The Planning Inspectorate
Yr Arolygiaeth Gynllunio

REPORT on the IMPLICATIONS for EUROPEAN SITES

Proposed Cleve Hill Solar Park

Planning Inspectorate Reference: EN010085

Site Location and European Sites
Figure 1

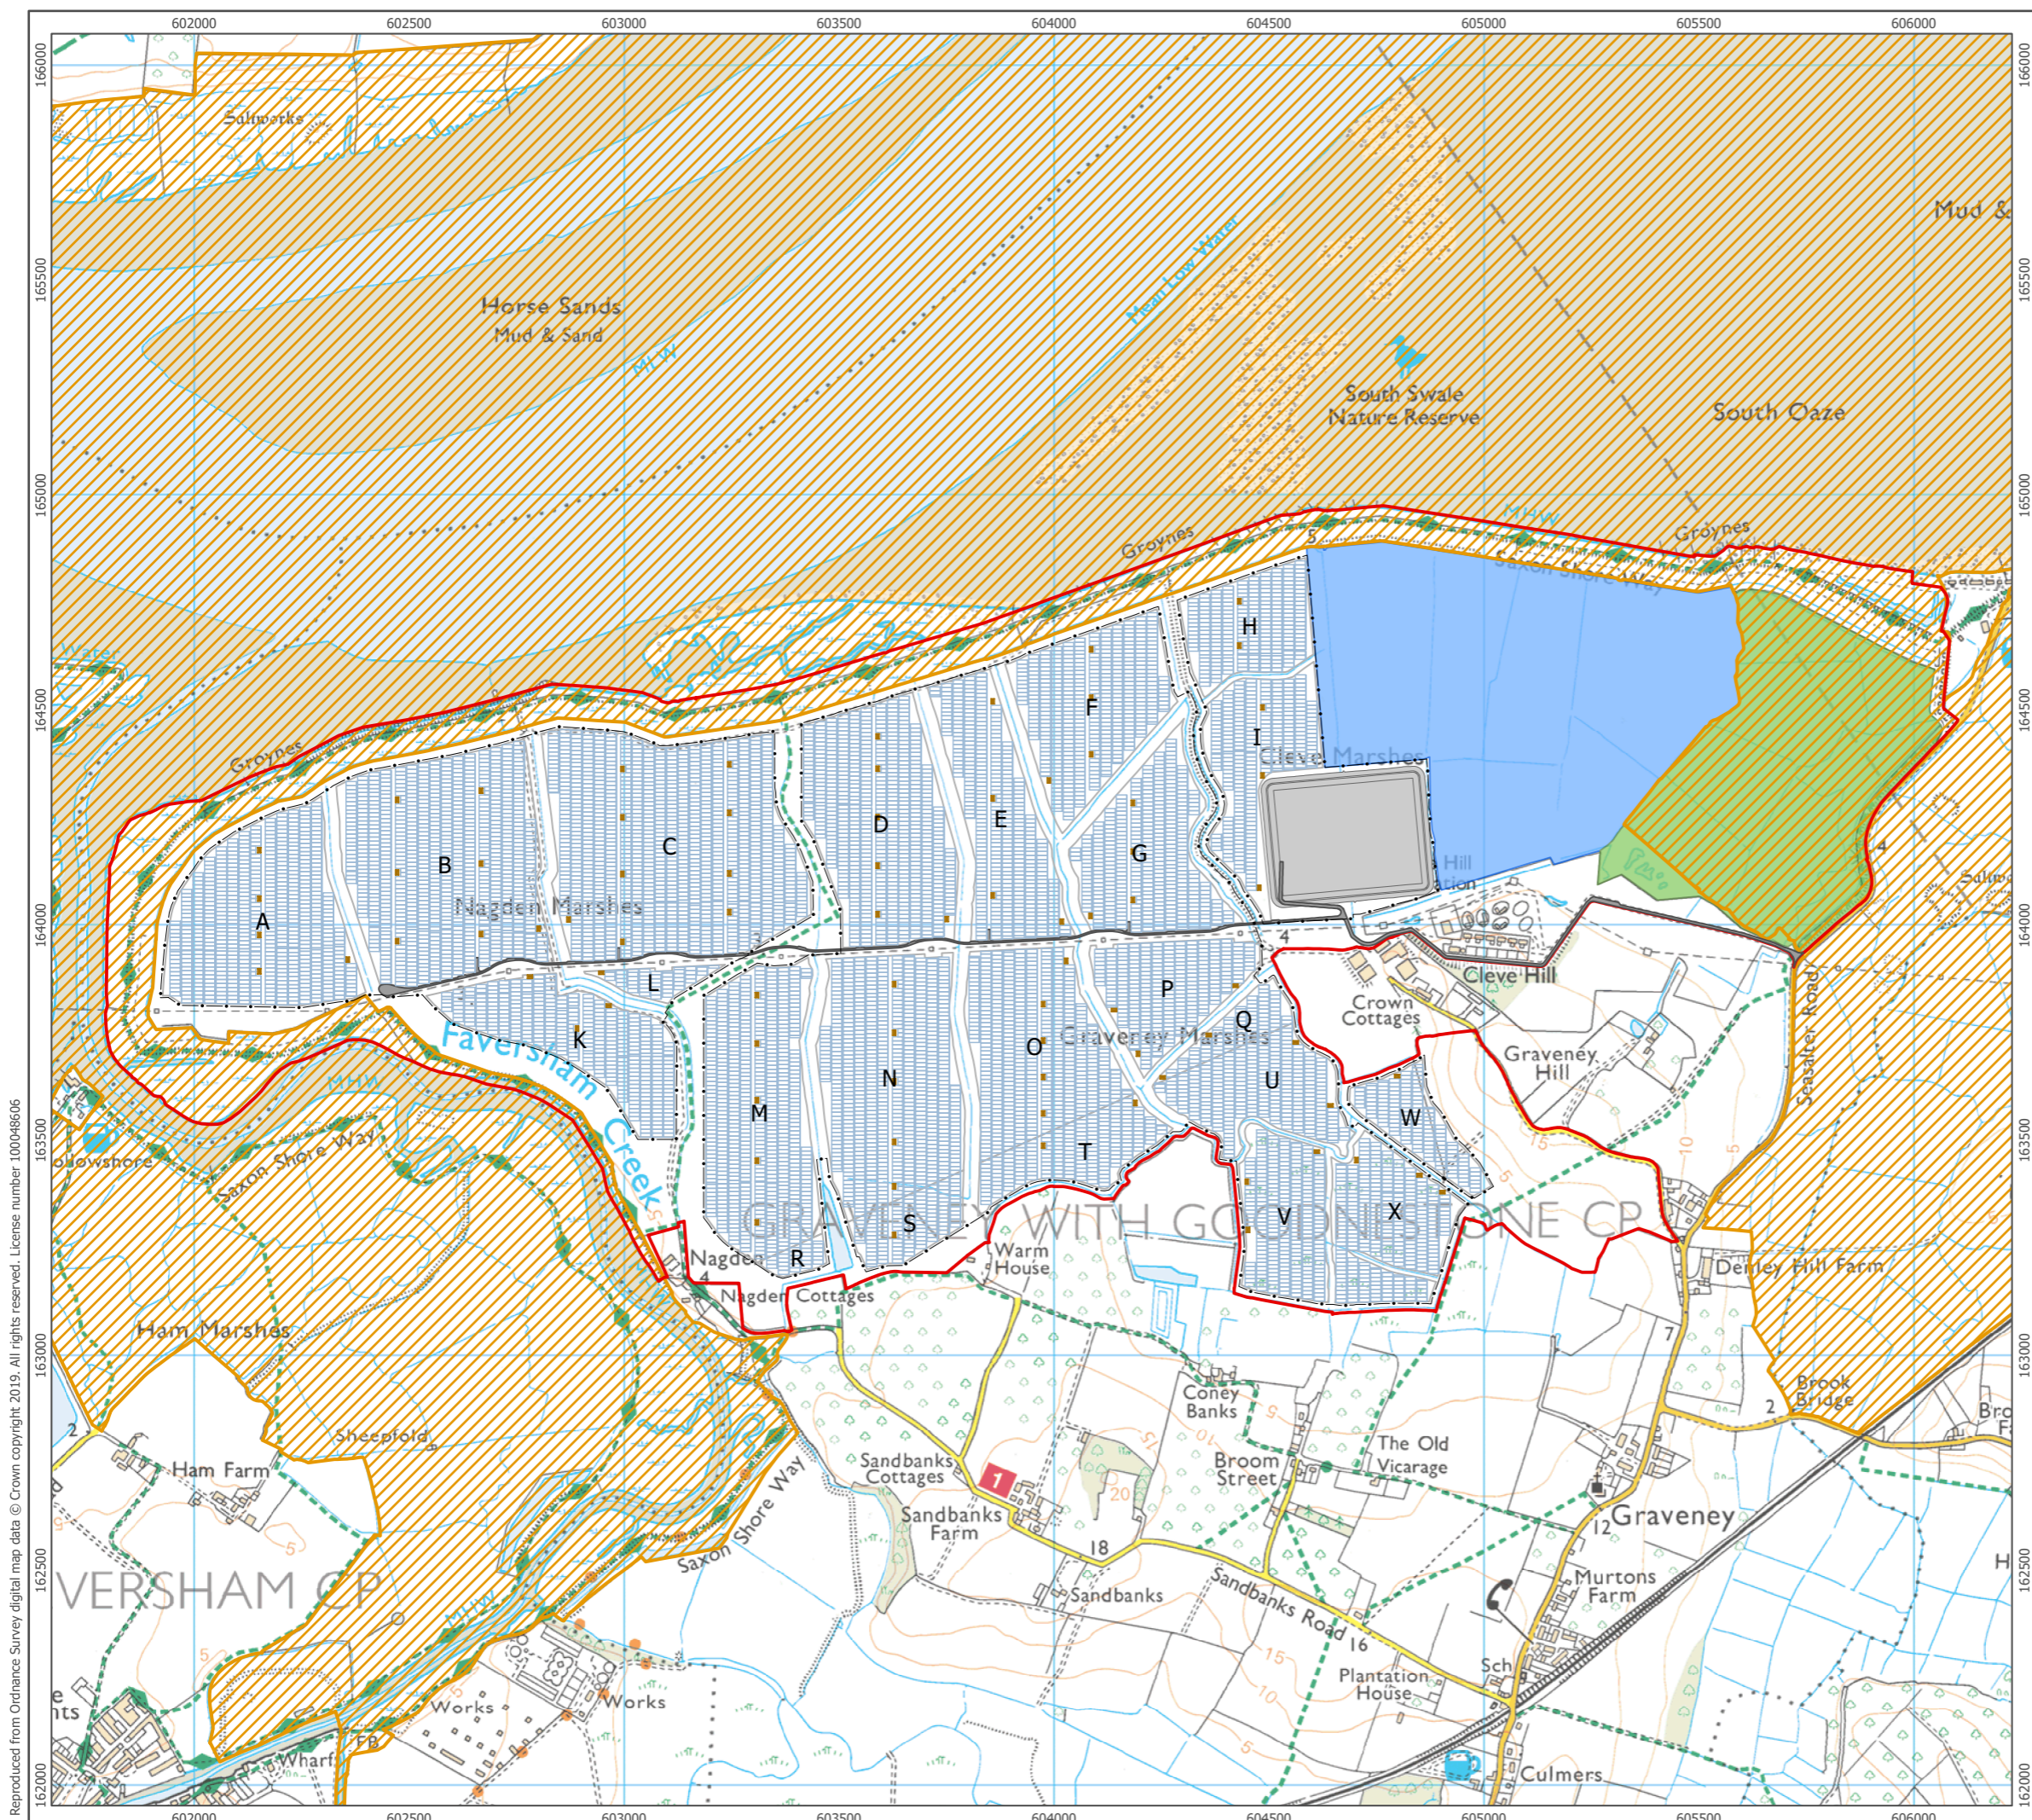
- 2.1.7 The locations of these European sites relative to the application site are illustrated on Figure 1 of the RIAA [**APP-026**]. The boundaries of the Swale SPA and Ramsar site are coincident. The northern, eastern and western extents of the application site include areas which are part of the Swale SPA and Ramsar site, as discussed further in Section 3 of this RIES.
- 2.1.8 The RIAA describes the application site as including land that is functionally-linked to the Swale SPA and Ramsar site; of importance to qualifying features and assemblage component species including dark-bellied brent goose (hereafter 'brent goose'), lapwing, golden plover and marsh harrier [**APP-026**]. The assessment presented in the RIAA is conducted on this basis.

2.1.10 Figure 1 of the RIAA [APP-026] illustrates the Thanet Coast and Sandwich Bay Ramsar site as covering the same area as the Thanet Coast and Sandwich Bay SPA. However, the Thanet Coast and Sandwich Bay Ramsar site is not identified in Table 1 of the RIAA [APP-026] as being potentially affected by the Proposed Development and no conclusion is presented in terms of potential for LSE on this site. As these sites cover the same geographical area, the ExA has assumed that the Applicant's conclusions presented in the RIAA in respect to the Thanet Coast and Sandwich Bay SPA also apply to the Ramsar site.
